Addendum No. 1

RE: Contract # C203843
WBS # 53029.3.1
F. A. # NHPIM-0085(3)117
Guilford, Randolph Counties (I-5738, I-5789, I-5821)
I-85 From I-85 Business To Main Street In Archdale

June 21, 2016 Letting

TYPICAL SECTION NO. 1

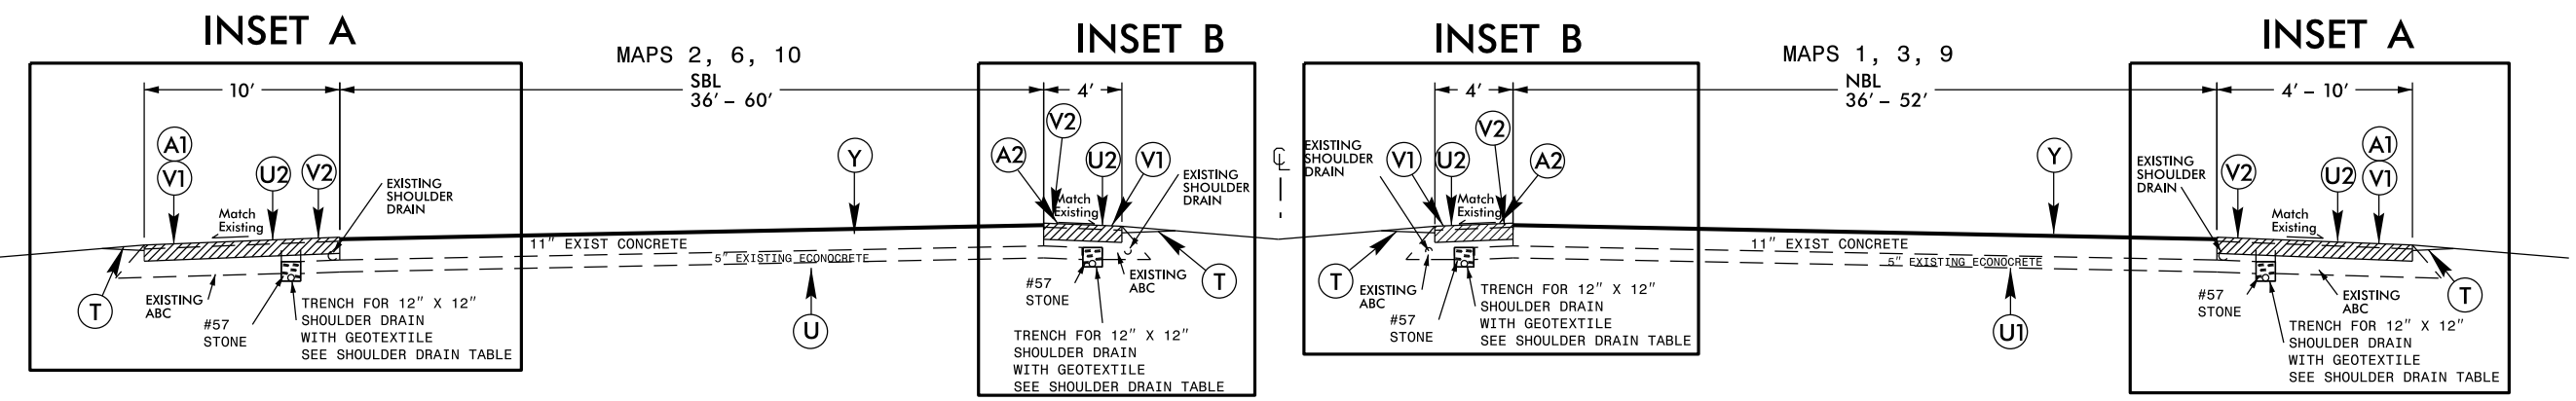
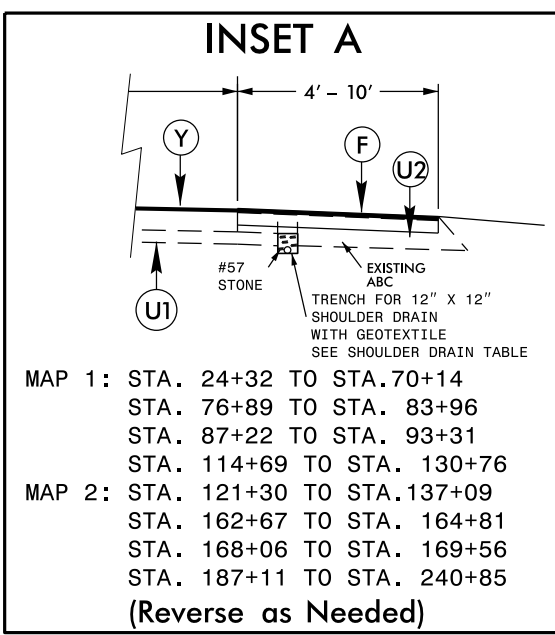
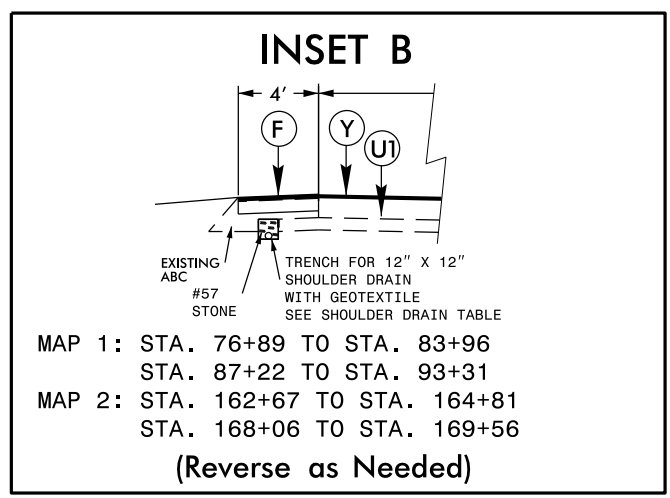
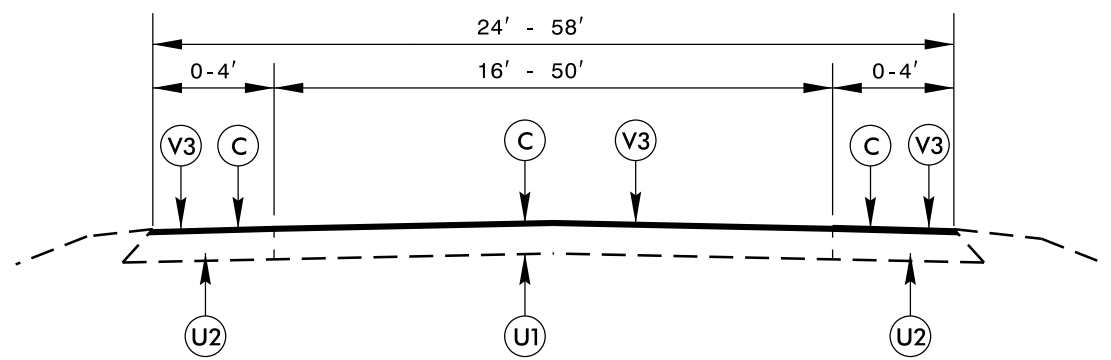
Sheet No.	Revisions
3	Notes were added/revised concerning the placement of joints
TMP-1B	Revised time restrictions in note A) and B)
